CITY OF ALBUQUERQUE

May 21, 2020

**RE: Sonta Trails Unit 4 Apartments
Conceptual Grading & Drainage Plan and Drainage Report
Engineer's Stamp Date: No Stamp Date
Hydrology File: C10D001A**

EXHIBIT 1 EXISTING BASINS

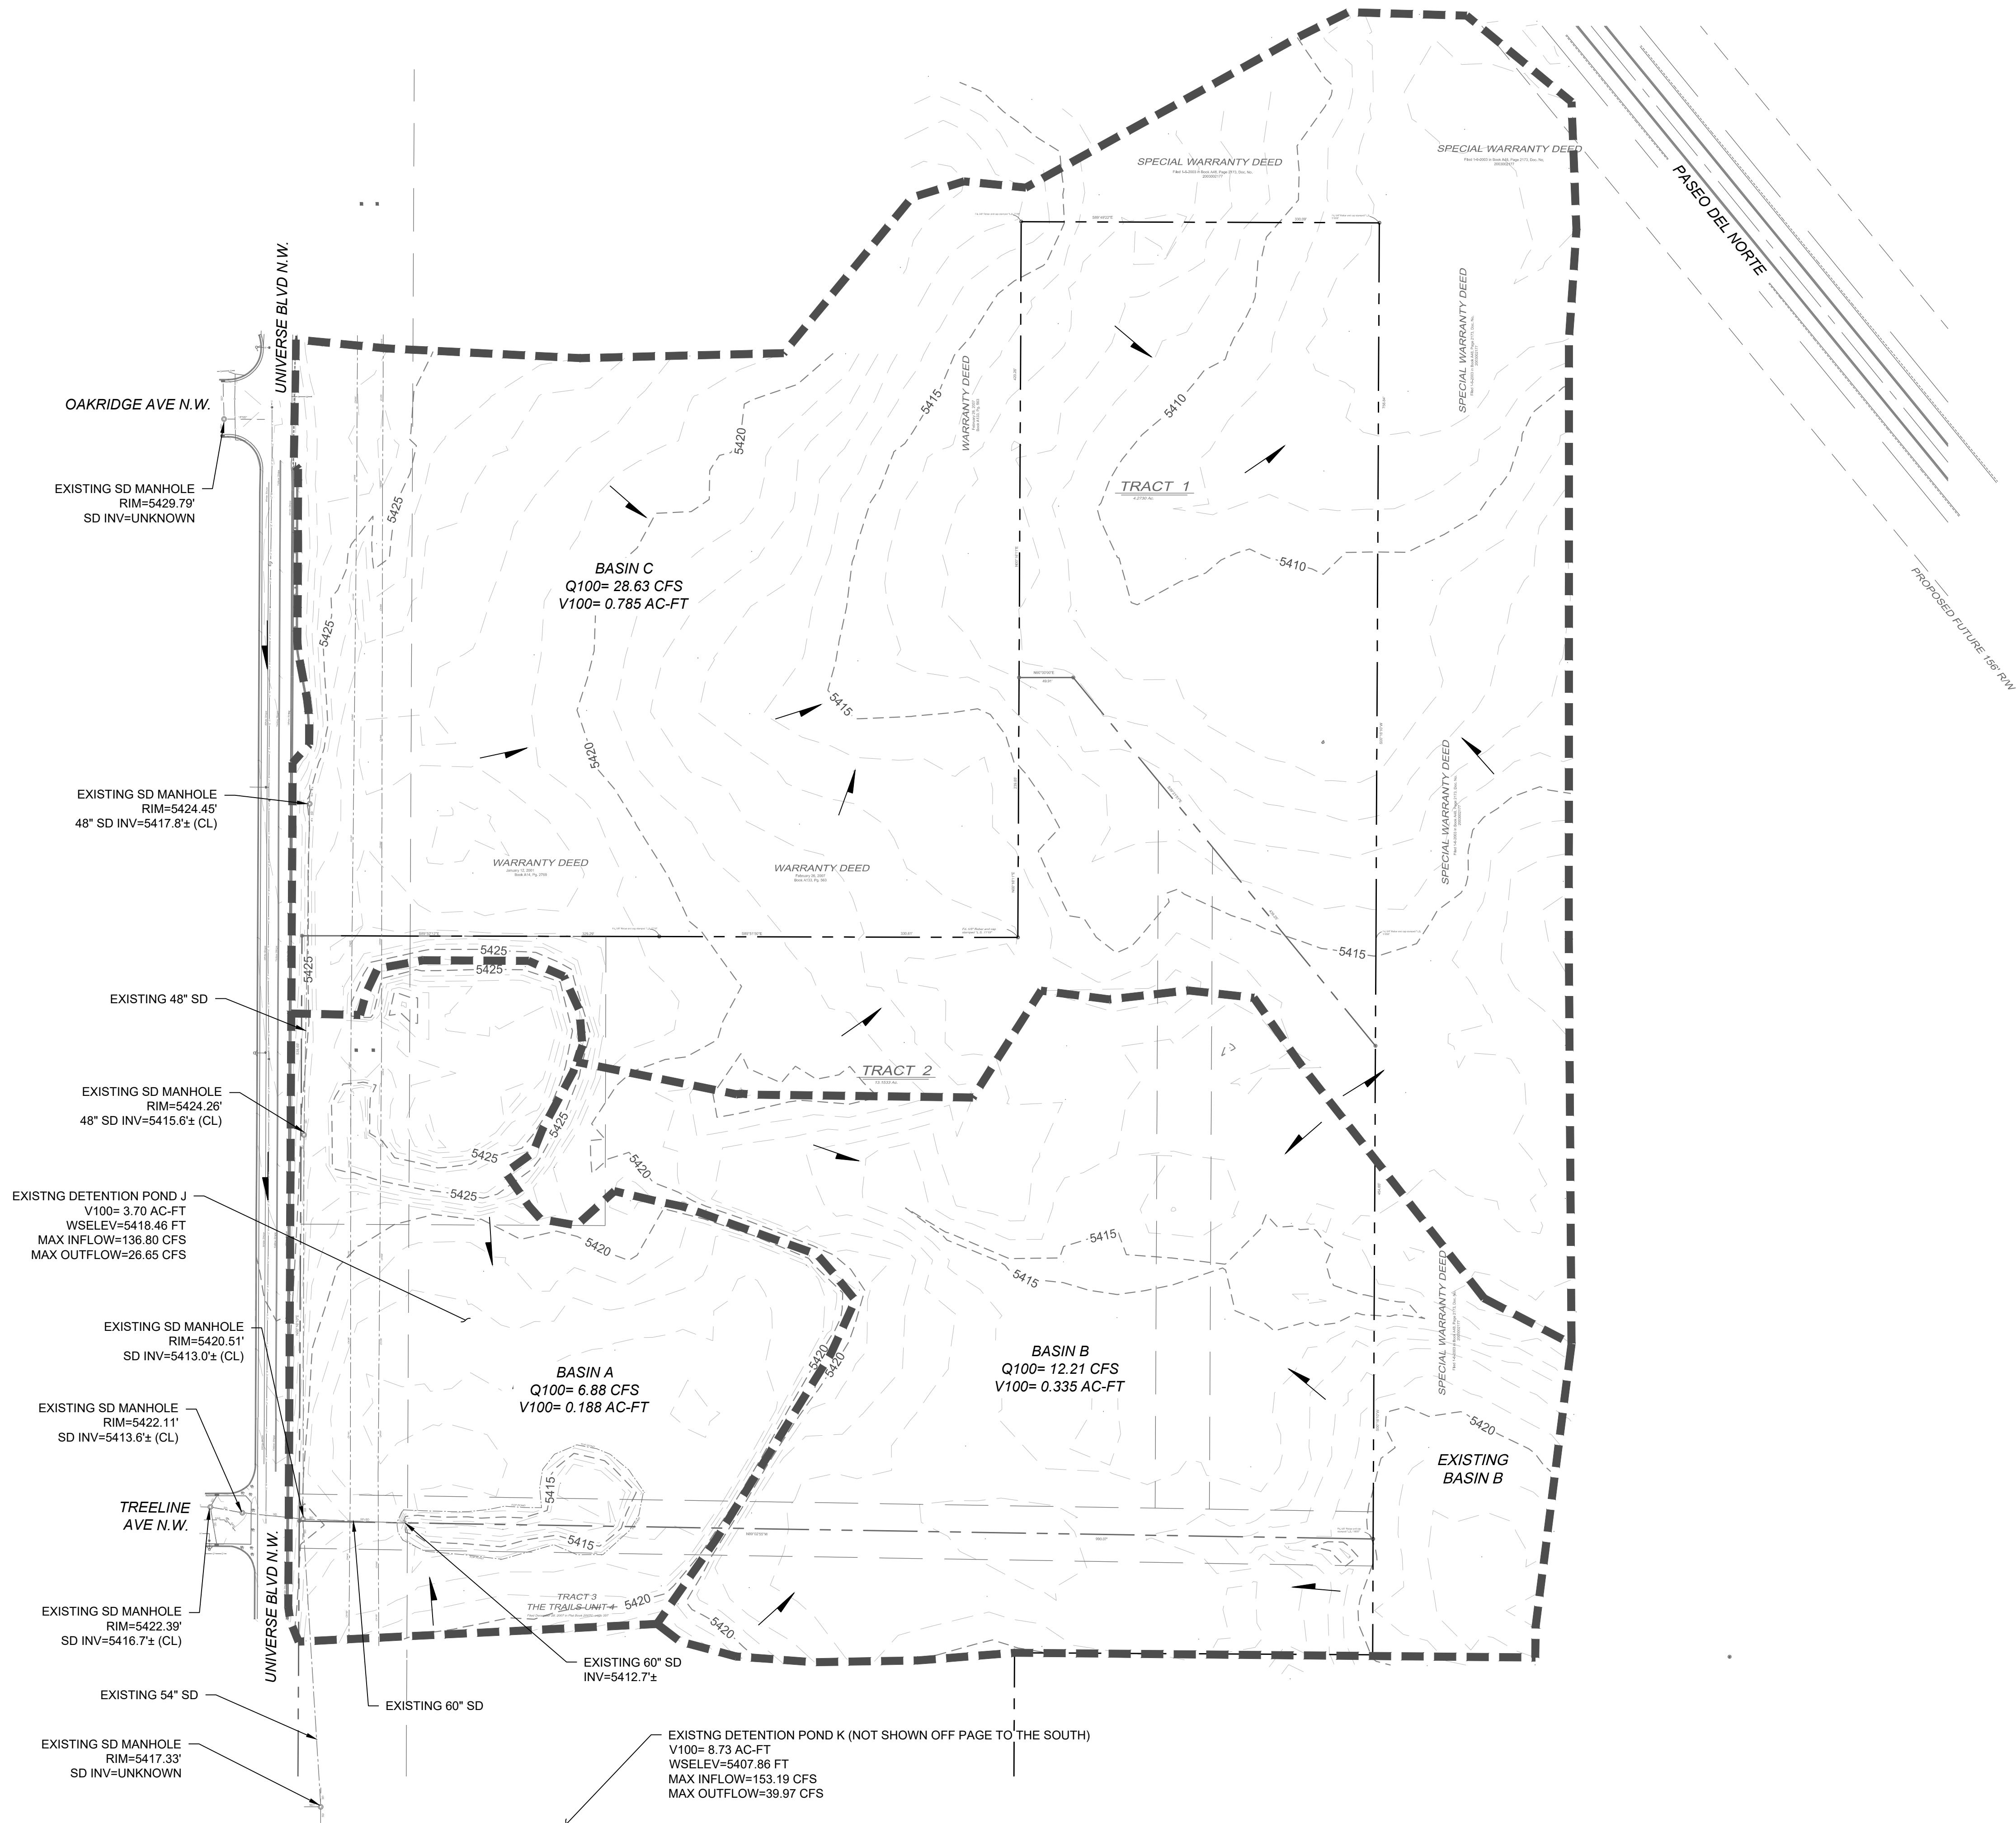
4. Please mention that the site also fall within "Upper Piedras Marcadas Watershed Drainage Management Plan by Wilson & Company dated April 2017.
5. Please also mention that the project ultimately drains into an Albuquerque Metropolitan Arroyo and Flood Control Authority (AMAFCA) facility (Piedras Marcadas Dam).
6. In reviewing Existing Basin B with provided existing contours and the City's LiDAR information, the existing Basin B does not drain to existing Basin C to the northeast but rather is drains to the southeast. Therefore the existing 12.21 cfs drains to the southeast, Please review and revised.

7. Since existing Basin B drains to the southeast, existing Basin C (28.63 cfs) and ½ of existing Basin A (3.44 cfs) drains to the northeast for a total of 32.07 cfs. Please review and revise.

EXHIBIT 2 PROPOSED BASINS

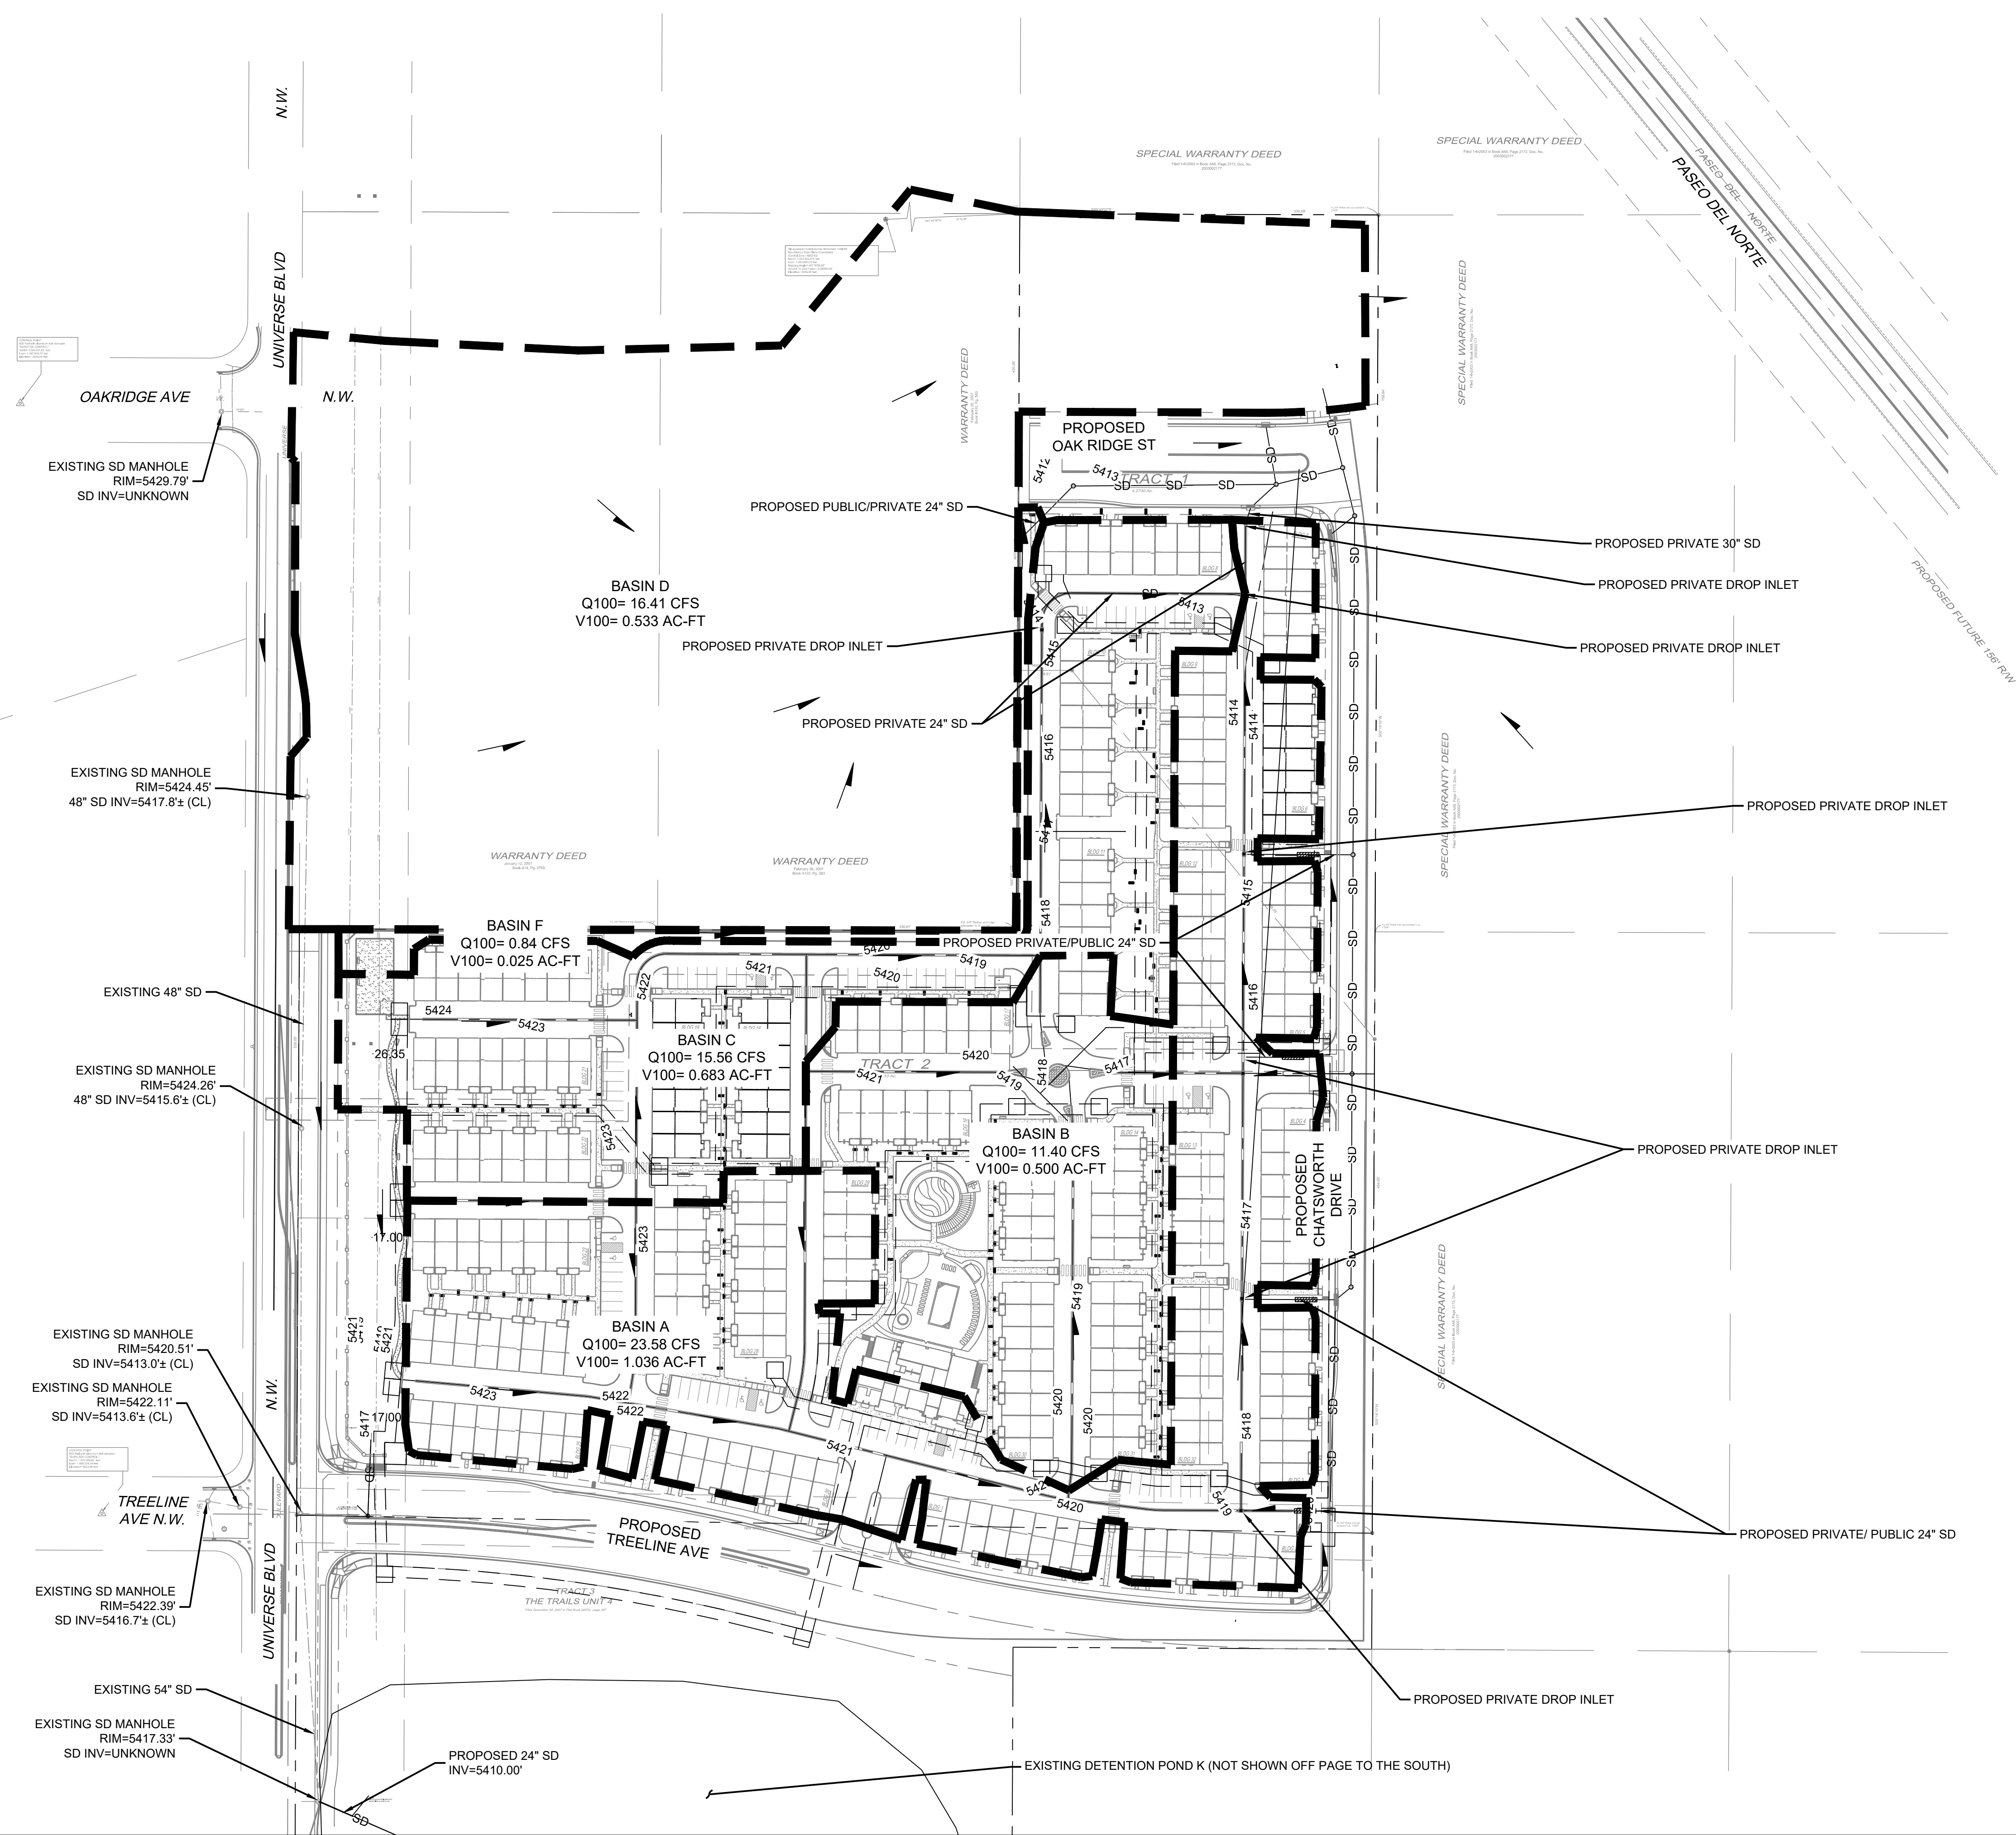
8. Therefore the proposed Basin A will only be allowed to discharge 32.07 cfs. Please review and revised both the design and the hydrologic calculation (AHYMO).

EXHIBIT 5 POND J

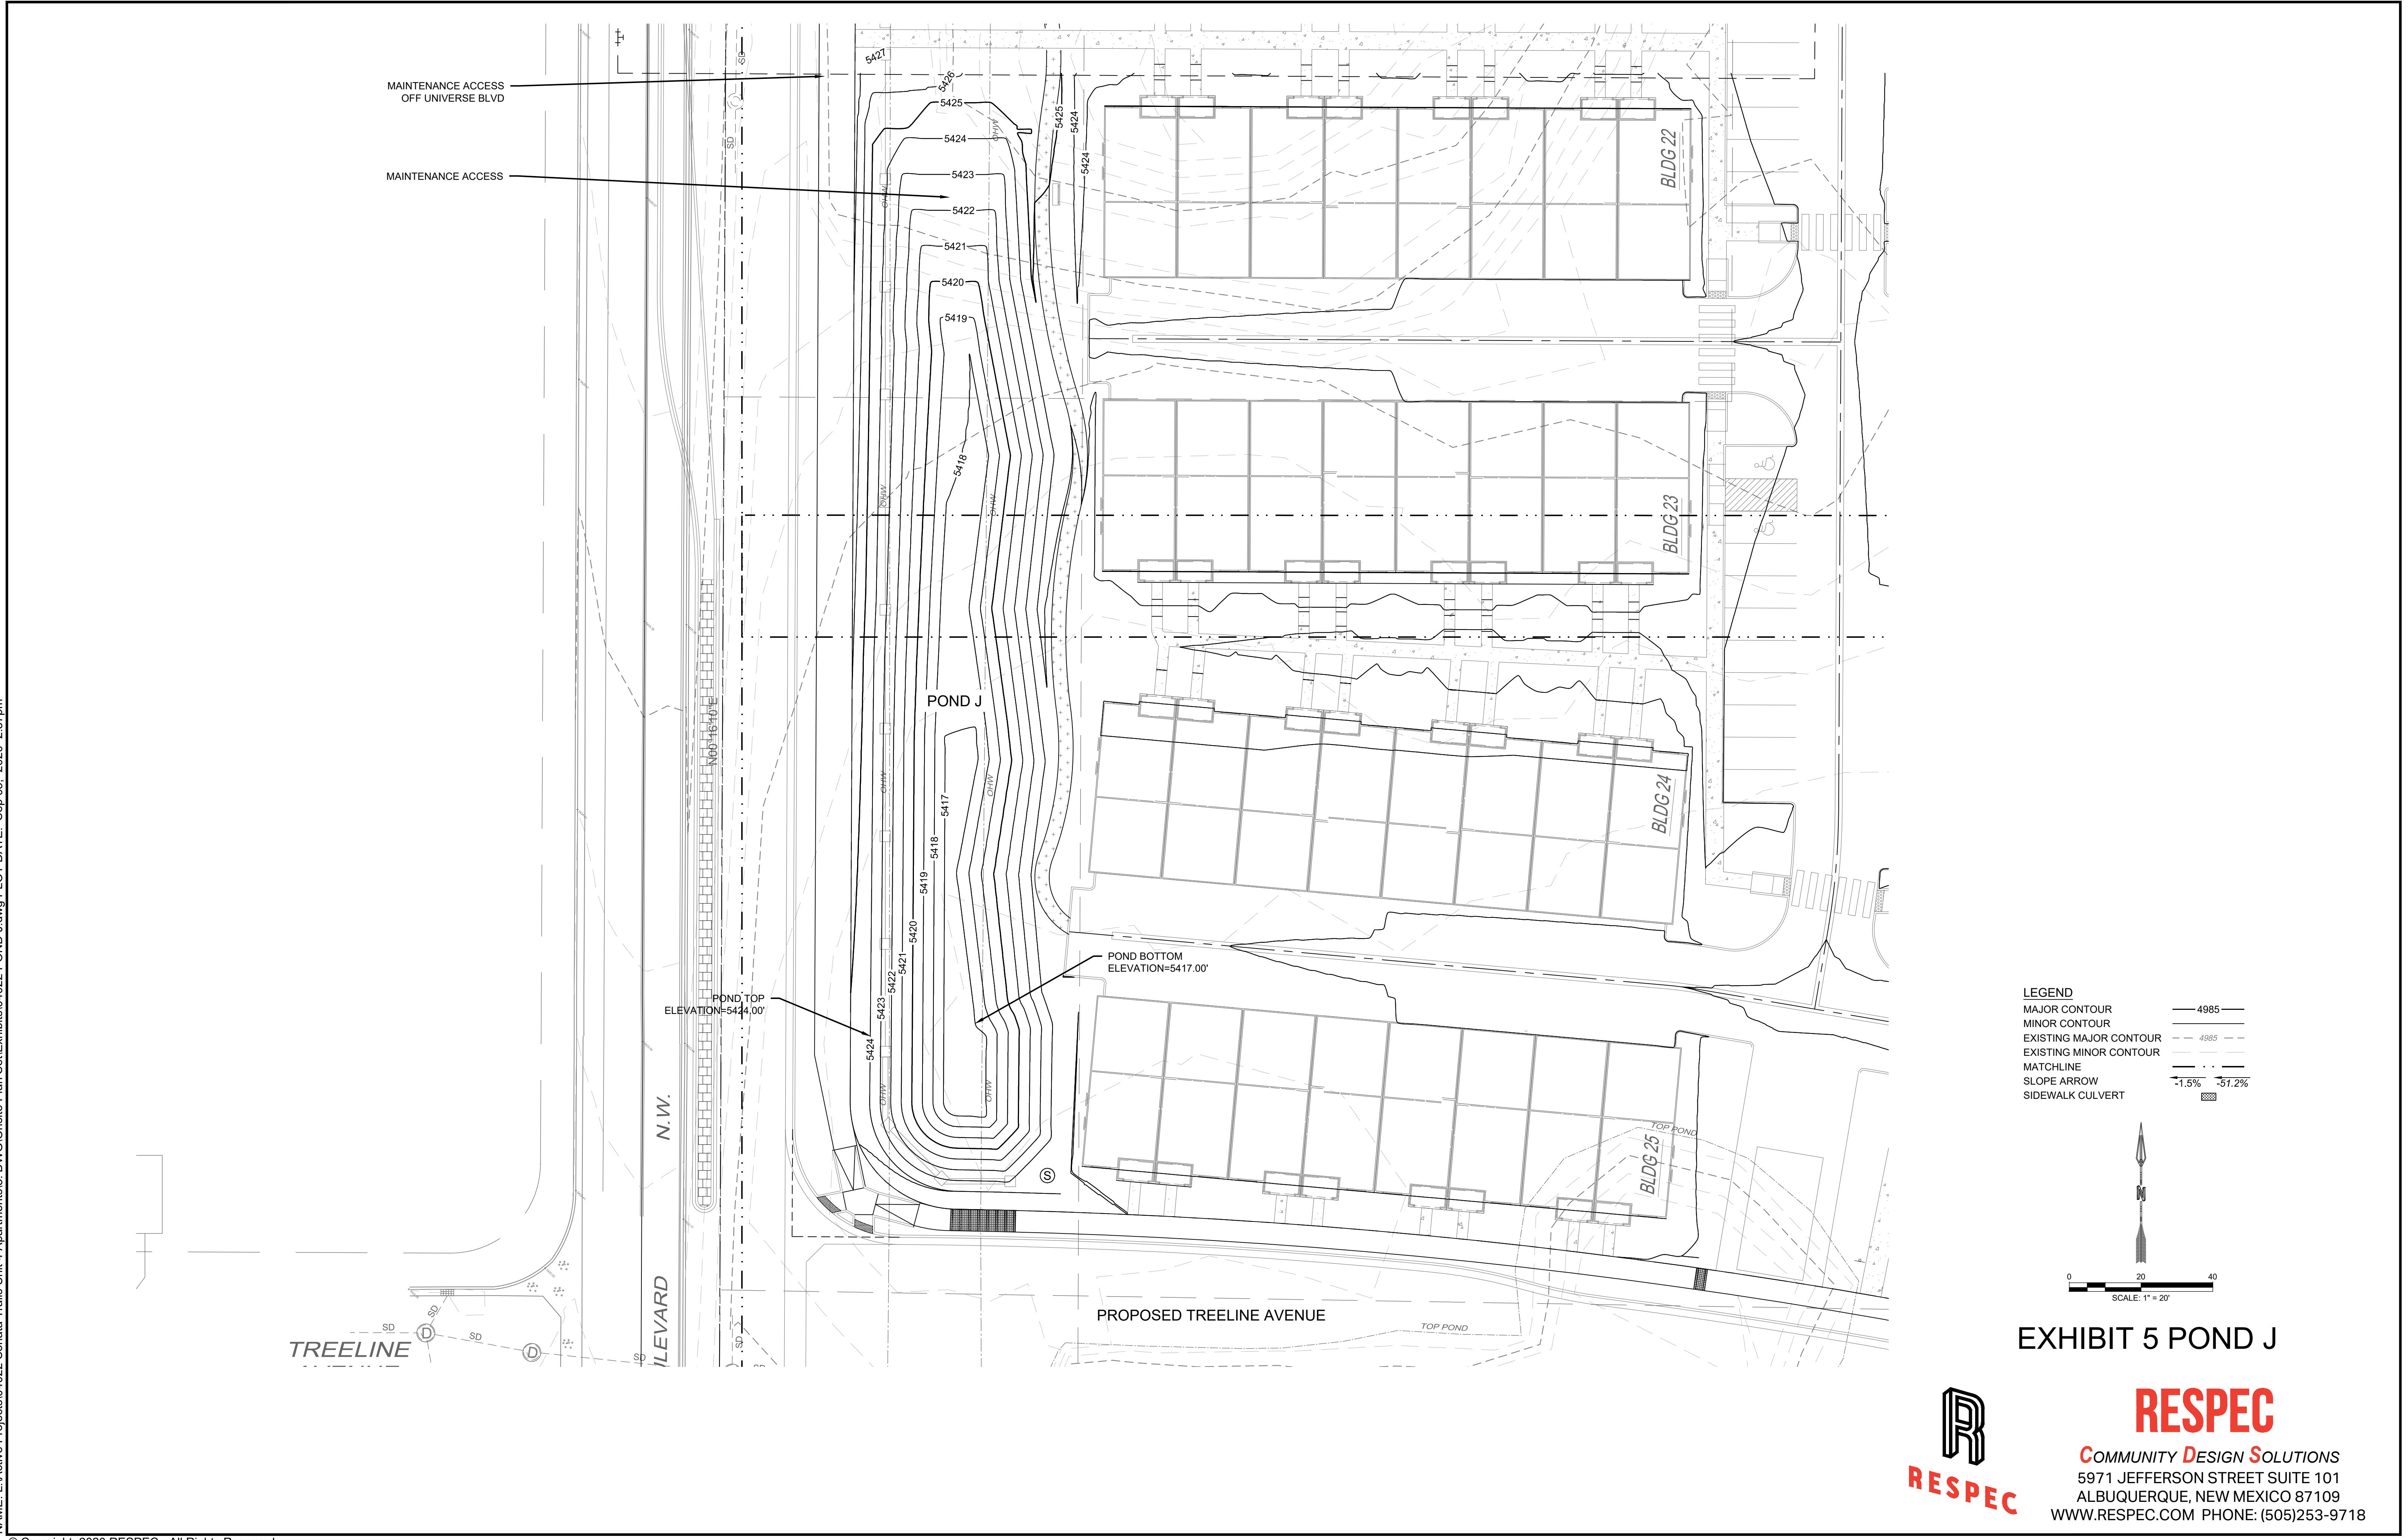
9. Based on the above comments, please revise the Conclusion of the Drainage Report.
10. Since existing Pond J is being modified with this project, please add a section in the Conceptual Drainage Report for this discussion of the work involved and provide calculations that show that this new pond size will be sufficient to handle the original design of Pond J.
